National Infrastructure Planning
Temple Quay House
2 The Square
Bristol, BS1 6PN

Our Ref: EN010154

Application by Fosse Green Energy Limited for an order granting development consent for the Fosse Green Energy

Procedural decisions following the acceptance of the application for examination

Figure 11-1

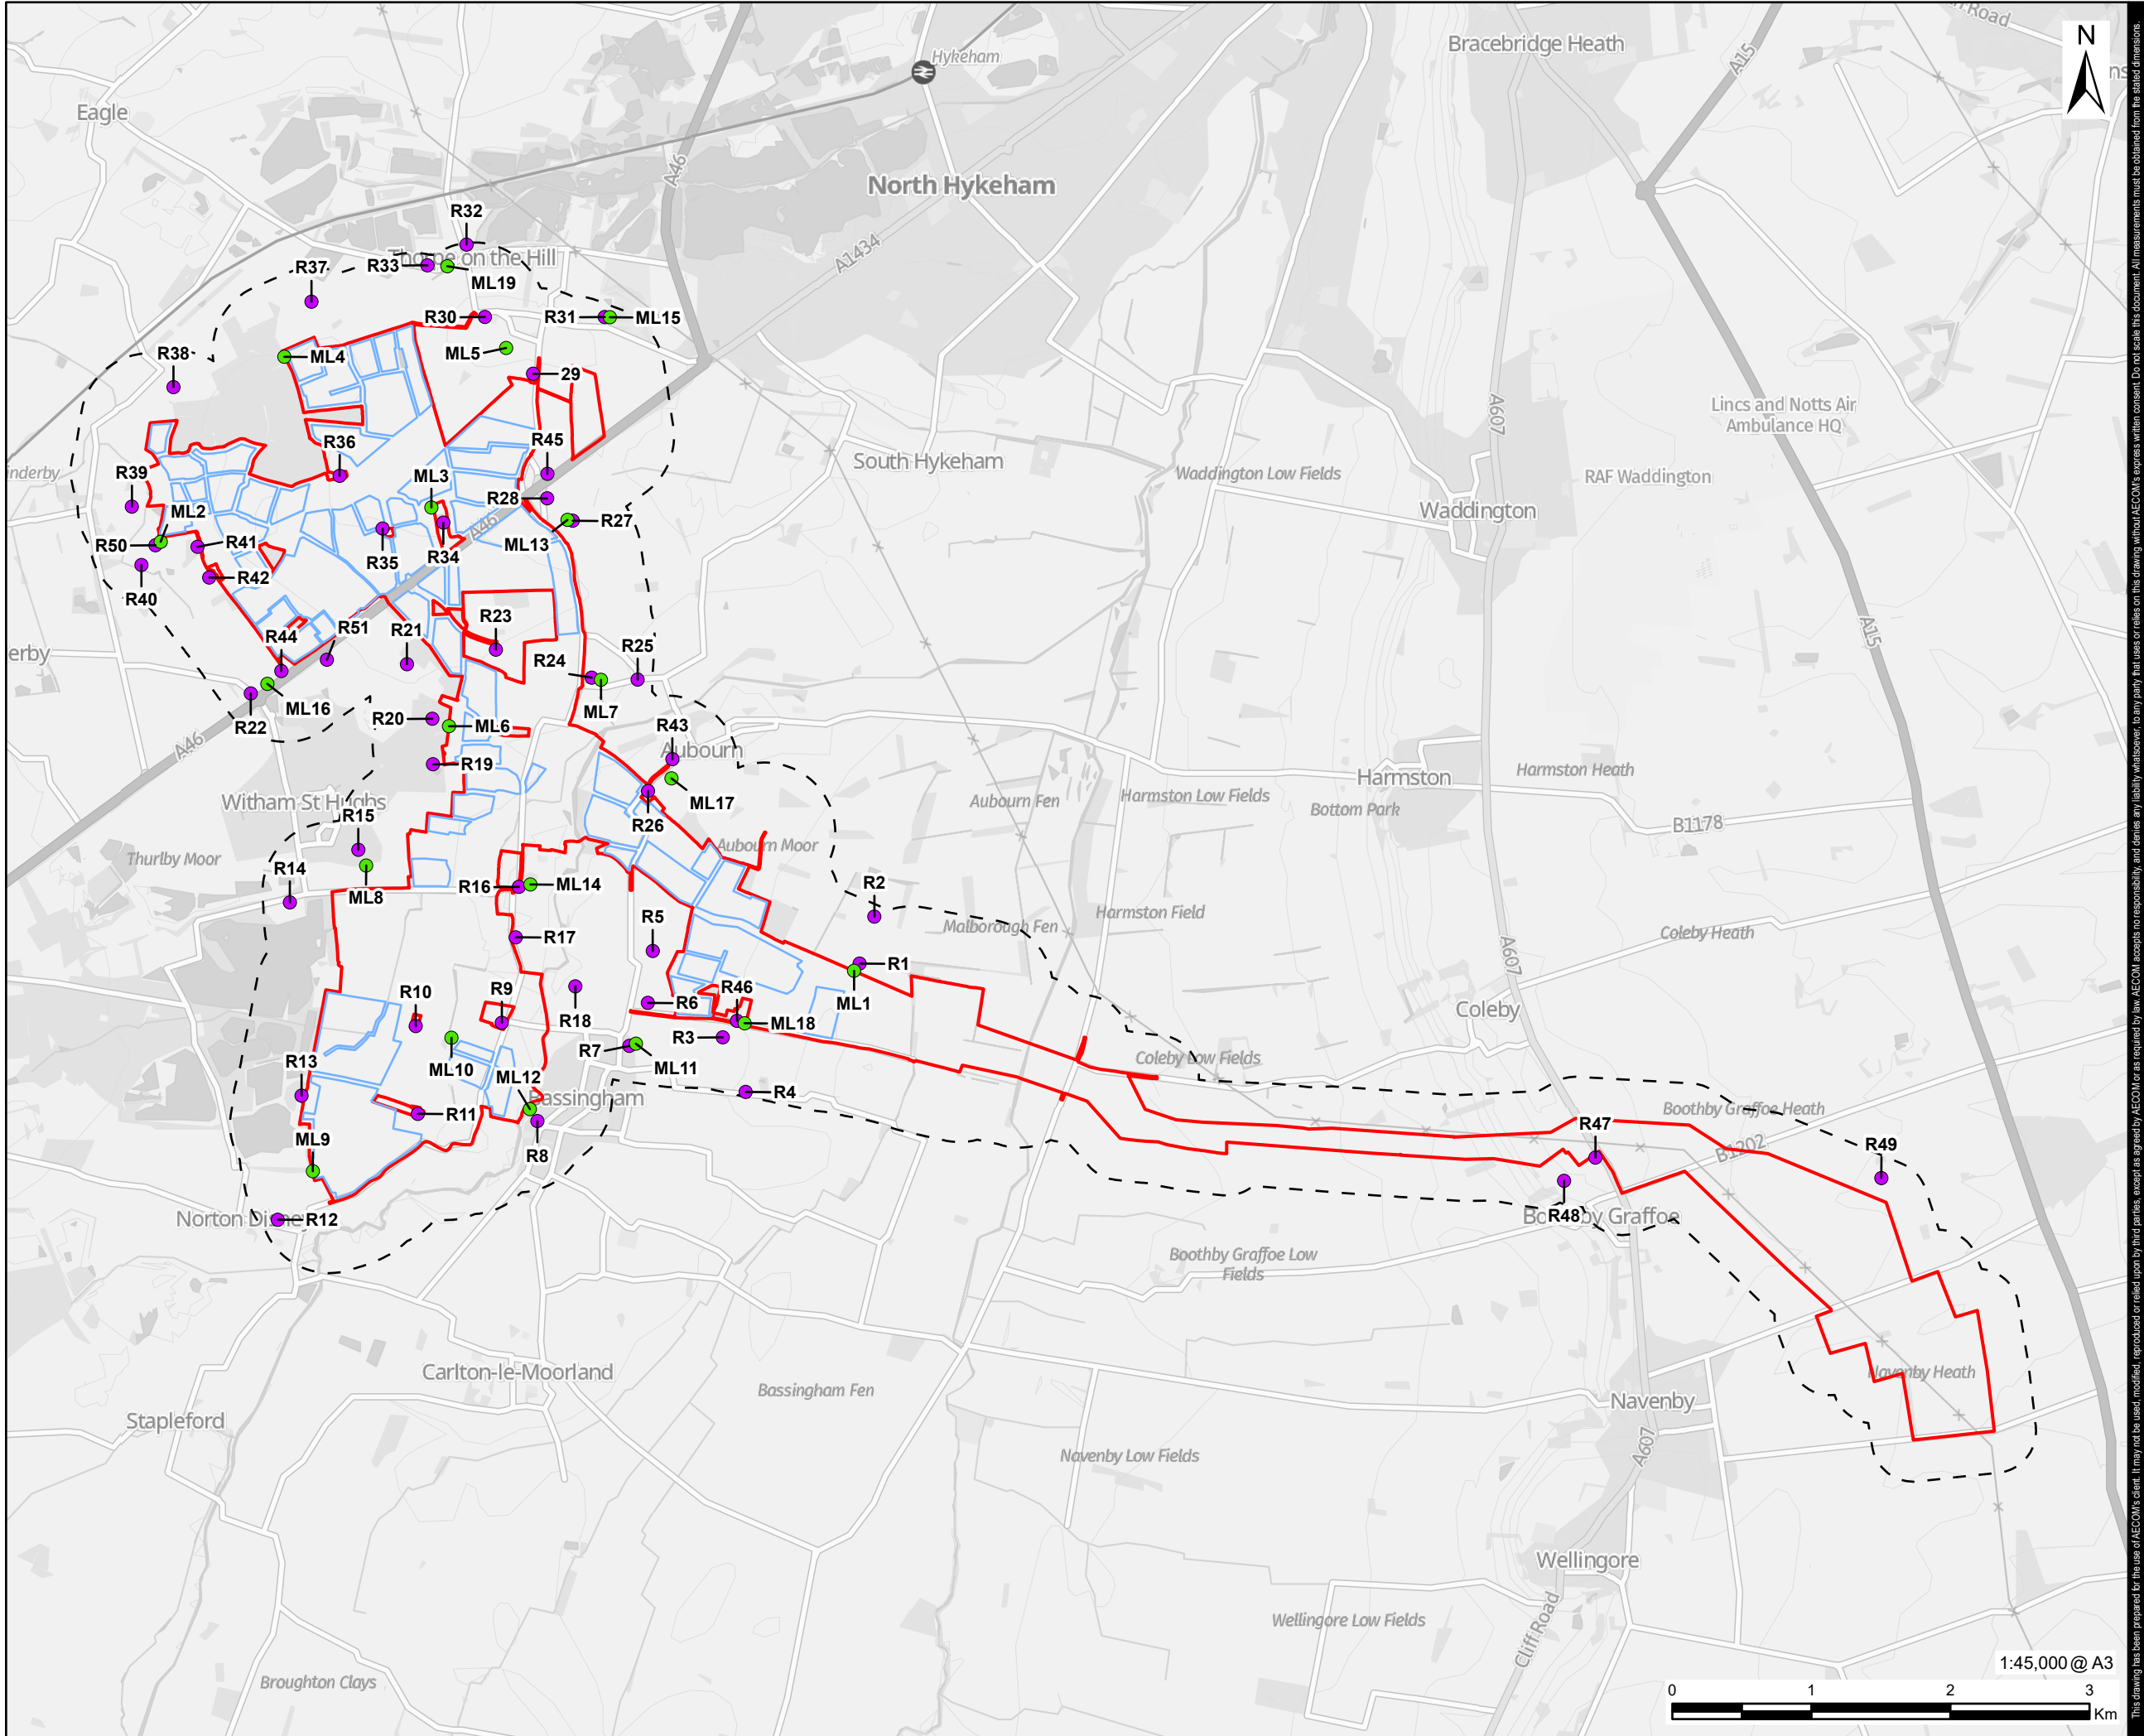
[PD-002] accompanying the decision to accept this application for examination the noise receptor and monitoring locations shown on ES Figure 11-1 [APP-099] are not readily identifiable because of the very limited contextual information included on Figure 11-1's map base and the scale this figure has been drawn at.

The ExA considers that revised plans and figures incorporating improved map base information **must** be submitted to aid the interpretation of the information depicted on the plans and figures included in Volumes, 2, 6.2 and 7 of the application documents.
